Landscape Review

*of the*  
**M3 Junction 9 Improvement**

*Prepared for*  
**South Downs National Park Authority**

*PINS Reference*  
**TR010055**

FIGURE 5
Existing and Proposed Highway Layout

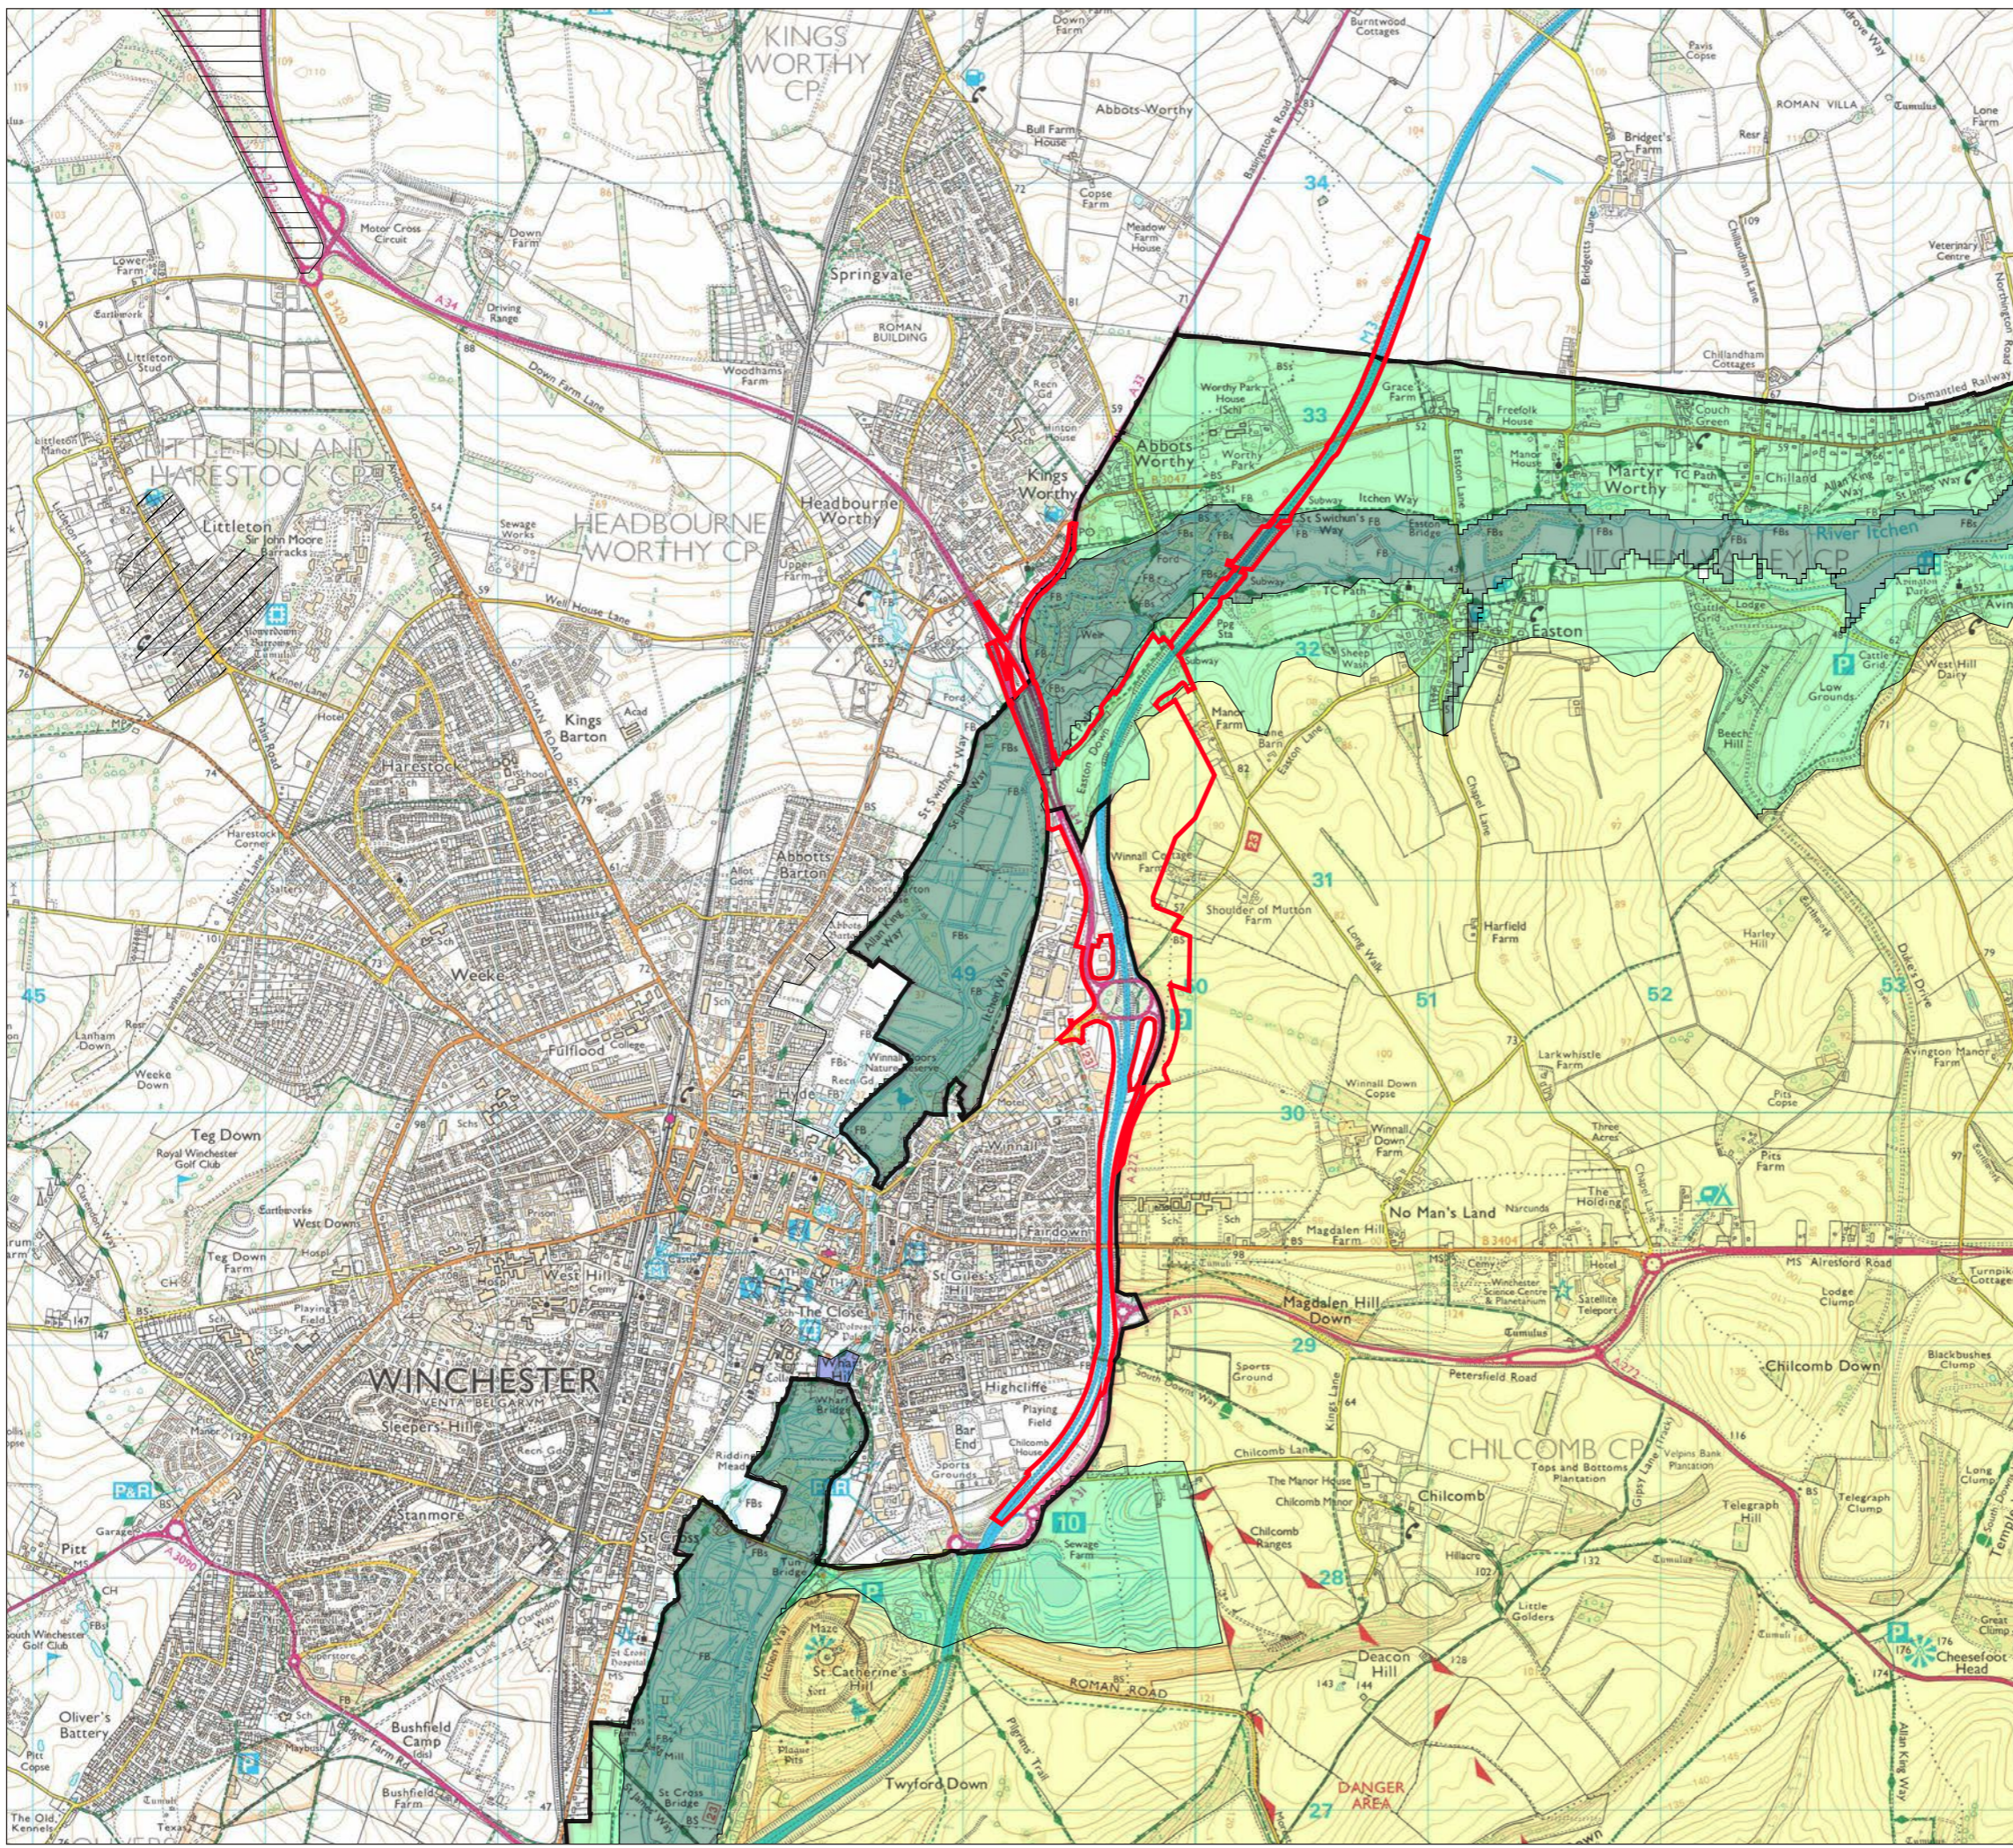
Summary of Issue	Recommendations	Further Information Requested
<b>Landscape Setting</b>		
<b>Issue 1: Earthworks (Figures 5 &amp; 6)</b>		
Cutting extending the motorway infrastructure into the SDNP. Loss of characteristic downland topography through spoil and re-profiling works.	Existing flowing downland topography east of the M3 is conserved as much as possible and any filling of deposition material is sympathetic to distinctive downland topography.	<ul style="list-style-type: none"> <li>• Shaded relief plan for the proposed final contours</li> </ul>
<b>Issue 2: Vegetation clearance (Figure 8)</b>		
<p>Approximately nine hectares of vegetation is proposed to be removed. Loss of trees along the eastern side of the M3 will open up views of the existing motorway, proposed new roads and increased activity from the east and from the west including from St Swithun's Way on the boundary of the SDNP (SDNP Representative View 62)<sup>4</sup>.</p> <p>It will also open up views towards built up parts of Winchester from the SDNP.</p>	Advanced planting is undertaken to minimise the opening up of views as much as possible.	<ul style="list-style-type: none"> <li>• Plan showing the location of the advanced planting, with an explanation for its rationale.</li> <li>• New photomontages from Viewpoints 3 &amp; 7 that accurately show the vegetation to be removed.</li> </ul>

FIGURE 7
Existing and Proposed
Rights of Way

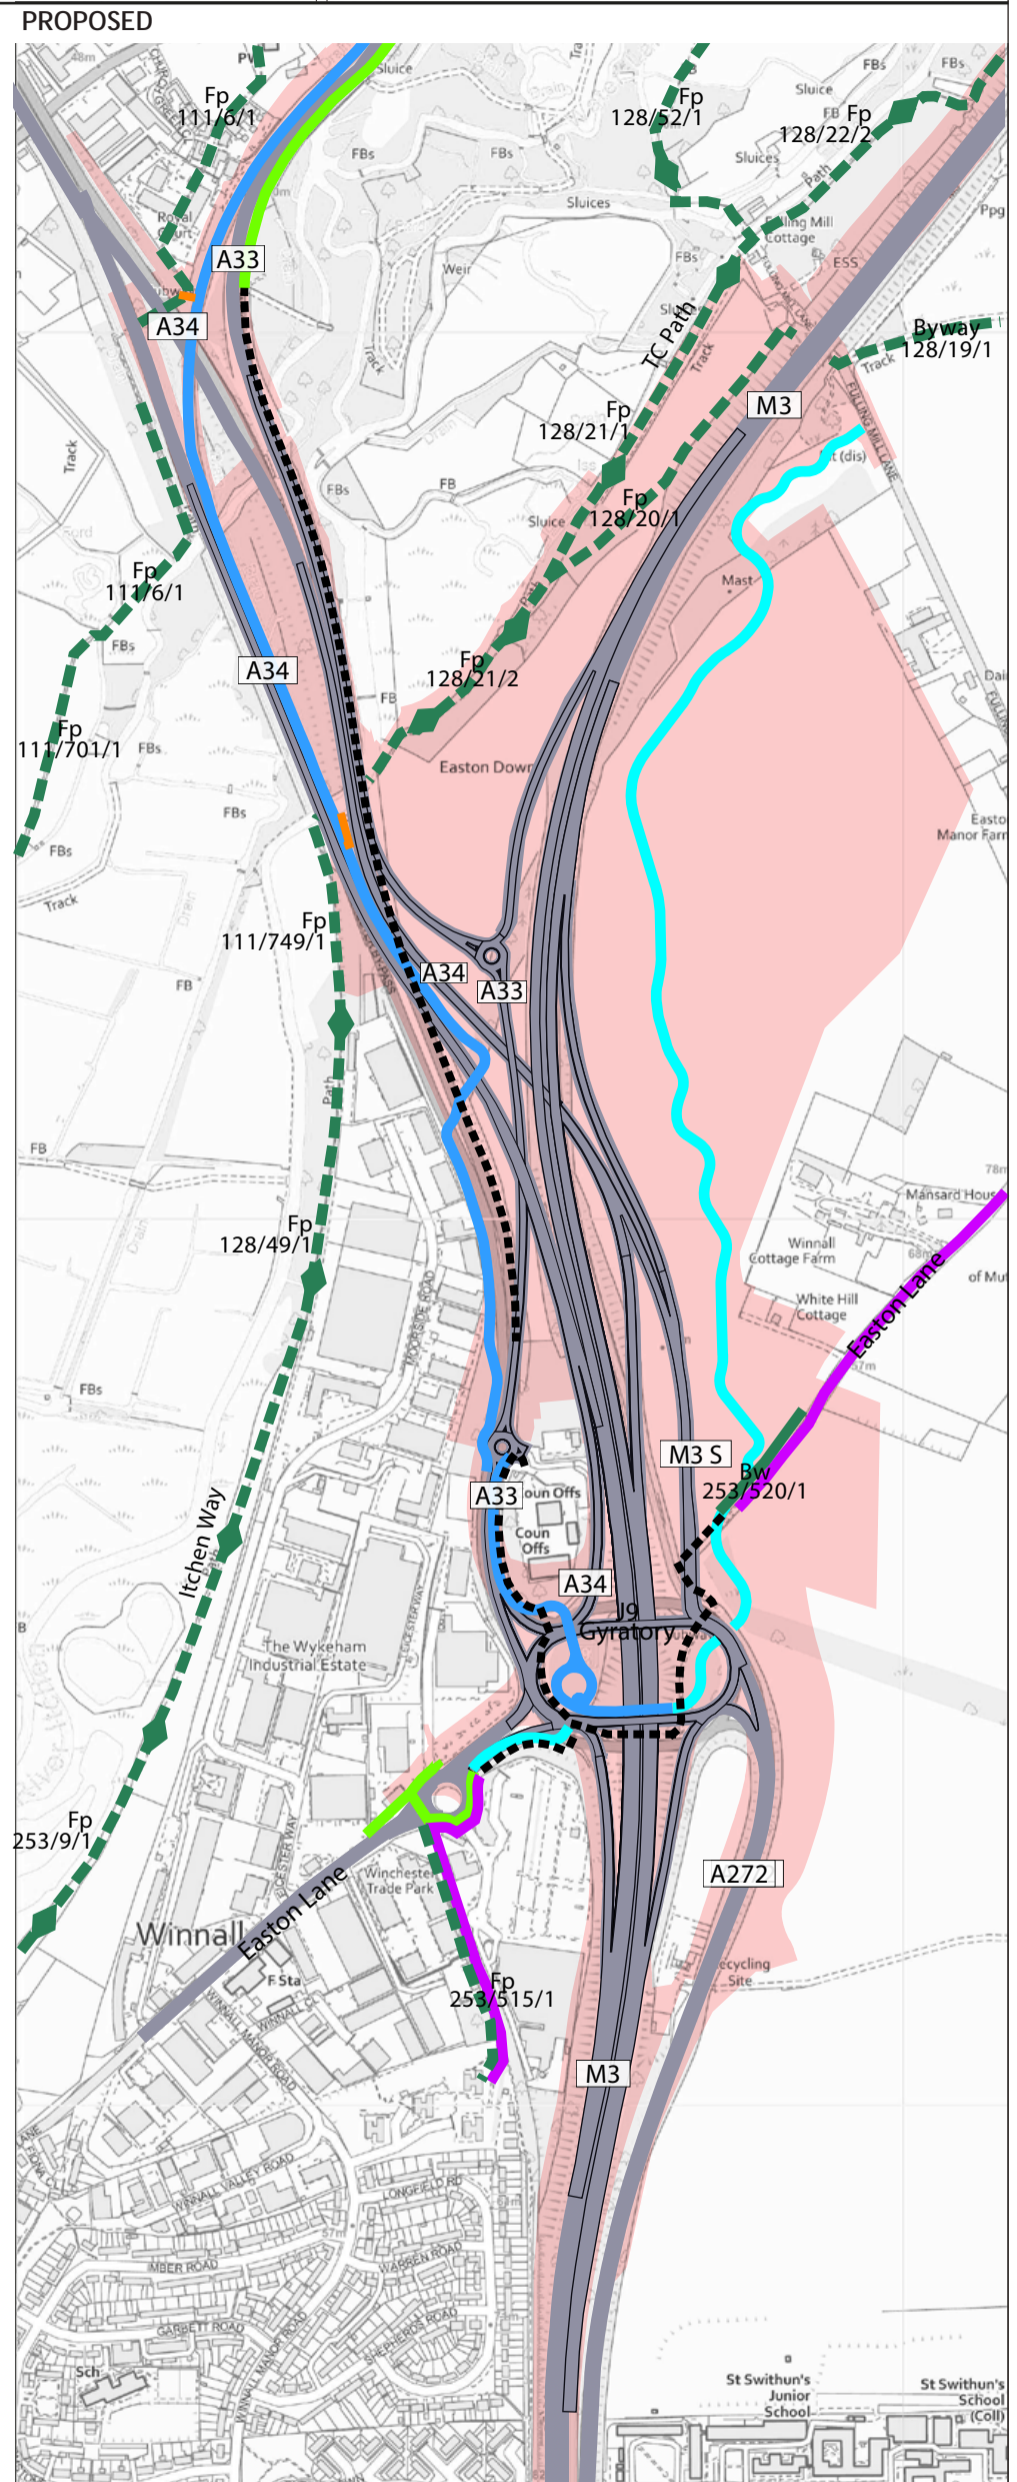
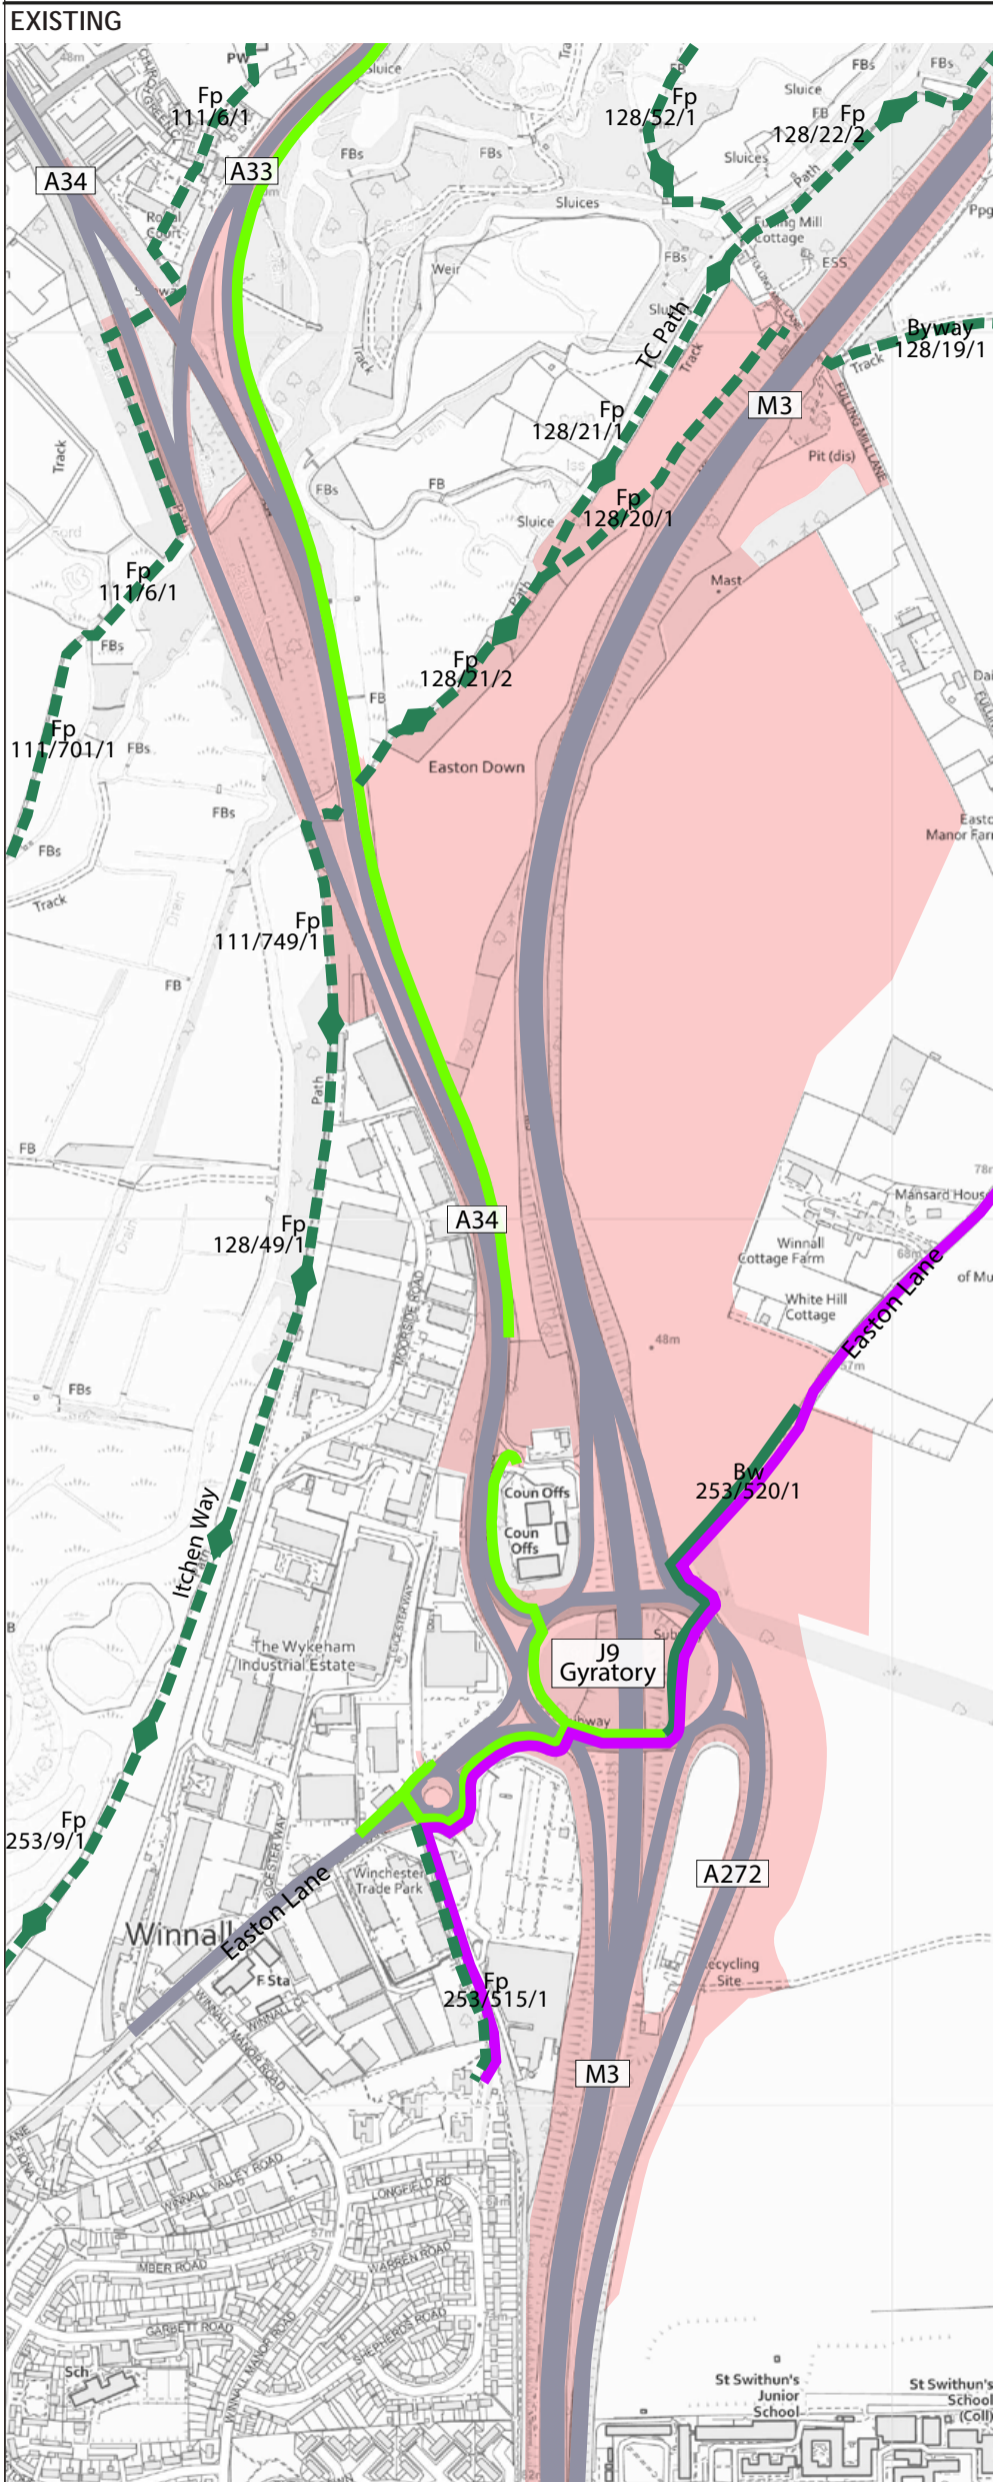
<b>Access to the South Downs National Park</b>		
<b>Issue 9: Proposed PRow upgrades (Figure 7)</b>		
<p>Upgrades are supported in principle because they would contribute to the SDNP priority of improving accessibility with the landscape within and around the SDNP.</p> <p>However, alignment of the proposed bridleway between Easton Lane and Long Walk is arbitrary and does not take the optimum route in landscape or visual amenity terms.</p> <p>The proposed PRow alongside the A33 and A34 are very close to the proposed carriageways and as such are unlikely to be attractive routes.</p>	<p>Realign the bridleway further east of the M3 or provide an alternative walking route further up the slope away from the motorway, where views are more extensive and the impact of passing vehicles on the amenity of the route is expected to be reduced.</p> <p>Provide further details on design measures taken to ensure routes alongside the A33 and A34 are attractive, through measures such as bunds between the walking and cycling route as well as replacement tree planting to provide additional cover and relief from the surrounding highway proposals.</p>	<ul style="list-style-type: none"> <li>• Provide plan showing proposed PRow diversions during the construction phases.</li> <li>• Provide information as per our recommendations.</li> </ul>

Issue 10: Proposed subways (Figure 7)		
<p>The existing subways are unattractive due to their narrow width and low height, and therefore design of new subways should seek to improve on this experience.</p> <p>The combined width of highways structures crossing the River Itchen will increase with the proposed 3.5m wide footbridge alongside the A34 northbound. This is expected to have an adverse impact on the Itchen Way which runs alongside the River Itchen and beneath the A34.</p> <p>Concern that the subways are not sufficiently wide to accommodate the proposed equestrian use.</p>	<p>Provide further details on the specific design measures taken to maximise the sense of spaciousness and the actual and perceived sense of safety within the subways including the route alongside the River Itchen.</p>	<ul style="list-style-type: none"> <li>• Confirm whether the proposed subways will have segregated or unsegregated foot / cycle routes.</li> <li>• Confirm that the subways are of sufficient width where equestrian use is proposed.</li> <li>• Provide explanation of design measures for safety with reference to use of lighting, materiality etc.</li> <li>• Provide details of relationship between the works and Itchen Way including any opportunities taken for enhancement of this route.</li> </ul>
